Application No: M/91/21/PL
Site Address: 27 Central Drive Middleton-On-Sea PO22 7TT
Description of works: Variation of condition 2-approved plans & removal of condition 4-materials included on plans imposed under M/25/19/PL.

Thank you for your internet representation made on 7th August 2021 which has been recorded as an objection with the comments as follows:

PROJECT	27 Central Drive - Elmer Beach	DATE	16/09/18
TITLE	Proposed South Elevation	DRG NO	IBA/507/05
SCALE	1 : 50	REVISIONS	B

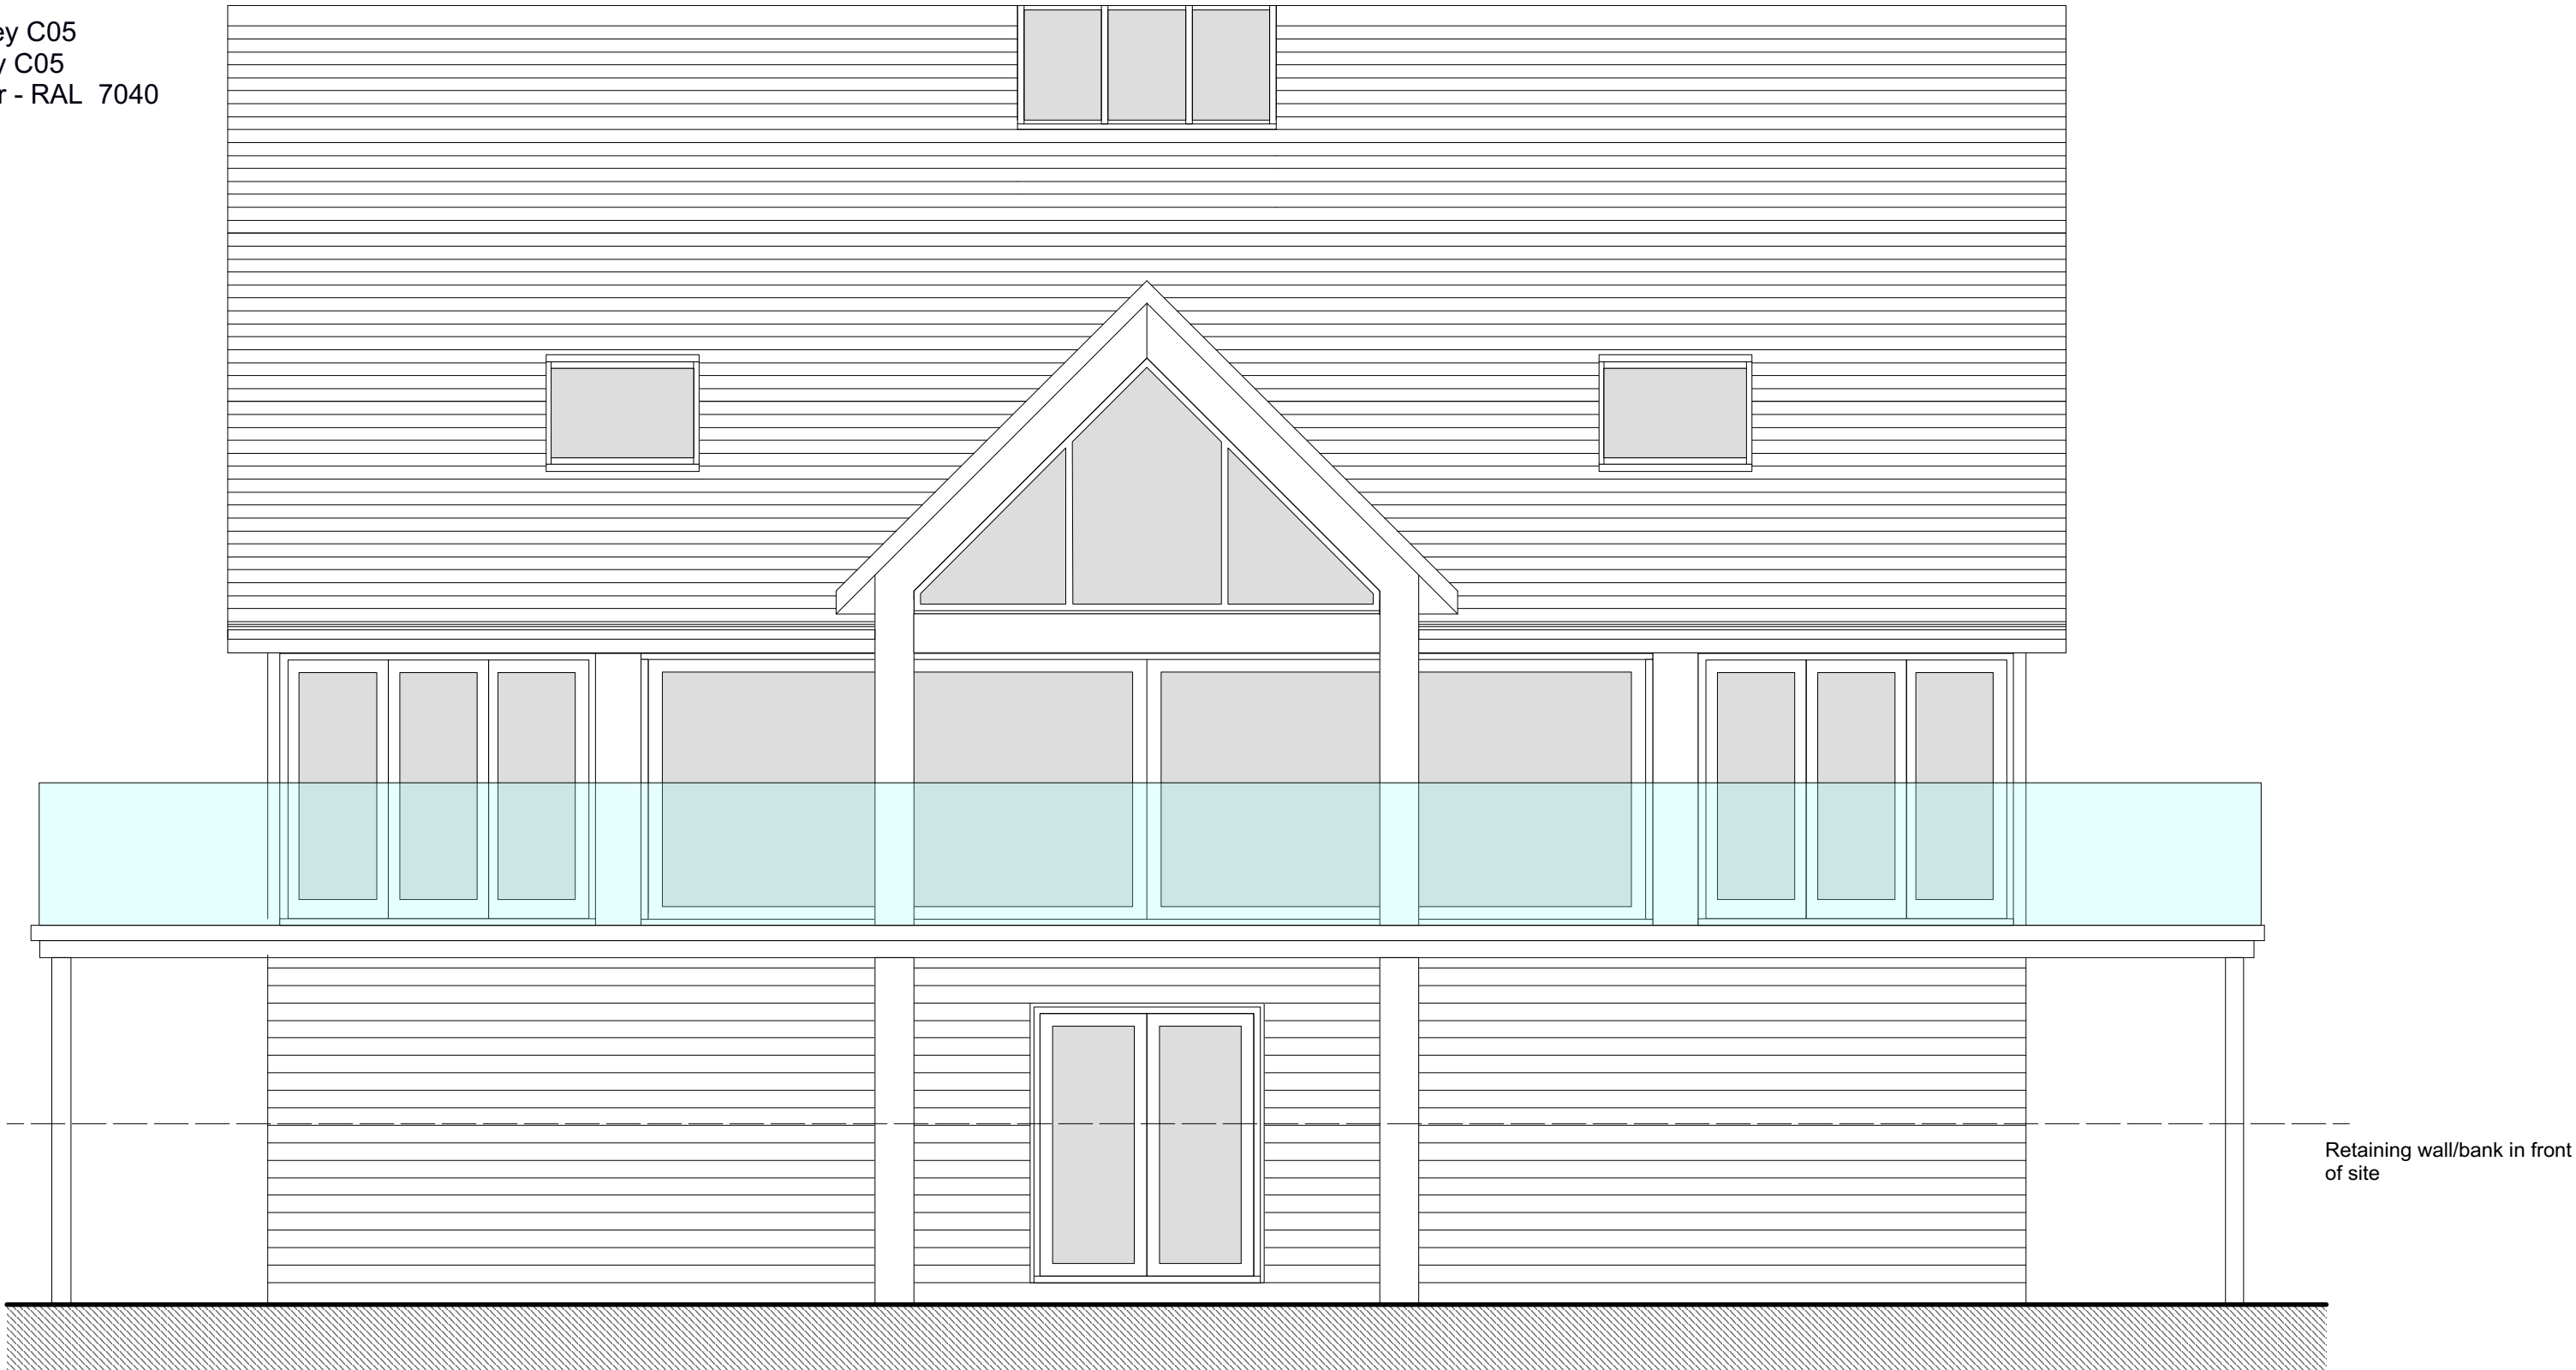
The roof as currently erected appears to have significantly deviated from the planning application that was submitted to Arun District Council Planning & Building Control (M/25/19/PL) in terms of both the elevation drawings submitted and the street scene. These both show the ridge line of the proposed building at number 27 Central Drive to be in line with the adjacent building at number 25 Central Drive.

The current roofline is resulting in an over-dominant presence when viewed from the beach and surrounding

properties and is out of keeping with the character and proportionality of our locality.
